10 February 2012

Subject: Pasminco Cockle Creek Remediation (06_0184 Mod 3)

Thankyou for the opportunity to comment on the proposed modification to the Pasminco containment cell.

Figure 3: Concept of proposed cell capping system

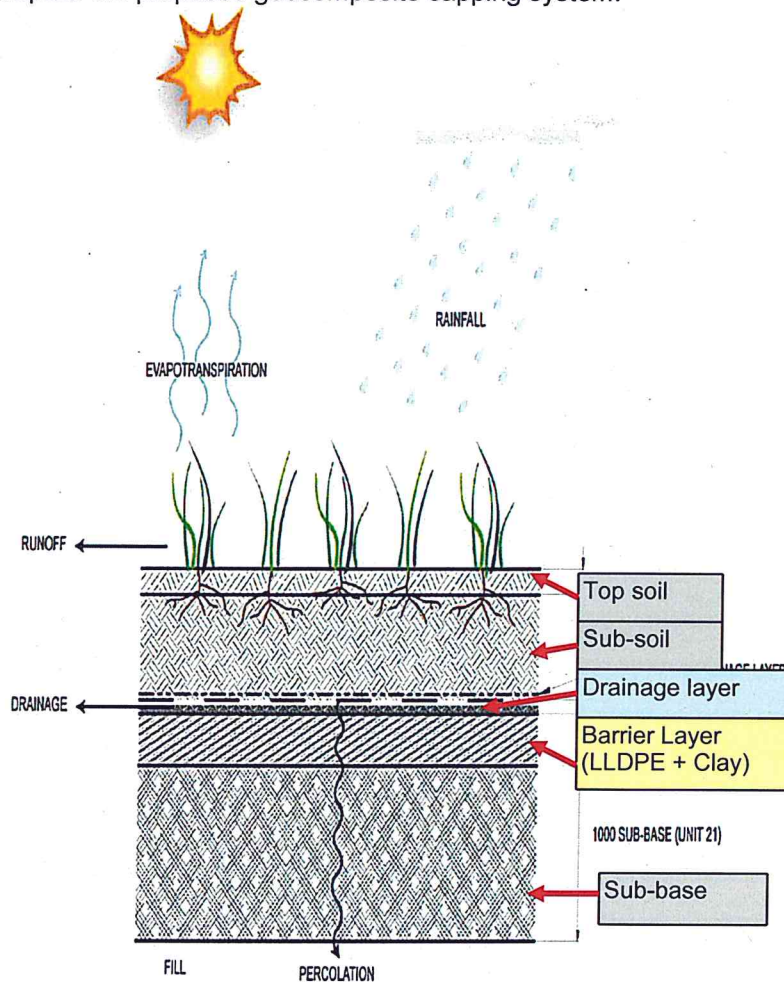
The EMP must address the potential for breaching the capping layer during any future building construction (if contemplated), or landscaping and restrictions to use of the site.

In this regard, site excavations to accommodate amenity buildings, lighting, and goal post construction may require breaching the capping layer, so the EMP will need to incorporate comprehensive work method statements for reference by construction personnel.

There will be, in addition to the capping layer, drainage layer, 600mm of subsoil and 150mm of topsoil, which will support vegetative coverage and shrubs etc, however it is Council's understanding that trees will be precluded due to the potential for their root systems to breach the capping layer and infiltrate the encapsulated contaminants.

It would be shortsighted at this stage to overlook the landscaping potential of this area, and for that reason, an inclusion within the audit statement may clarify their position on allowing or precluding flora.

A scaled site survey plan of the cell is produced which accurately identifies and delineates both the existing 600mm and proposed composite capping layer on completion.
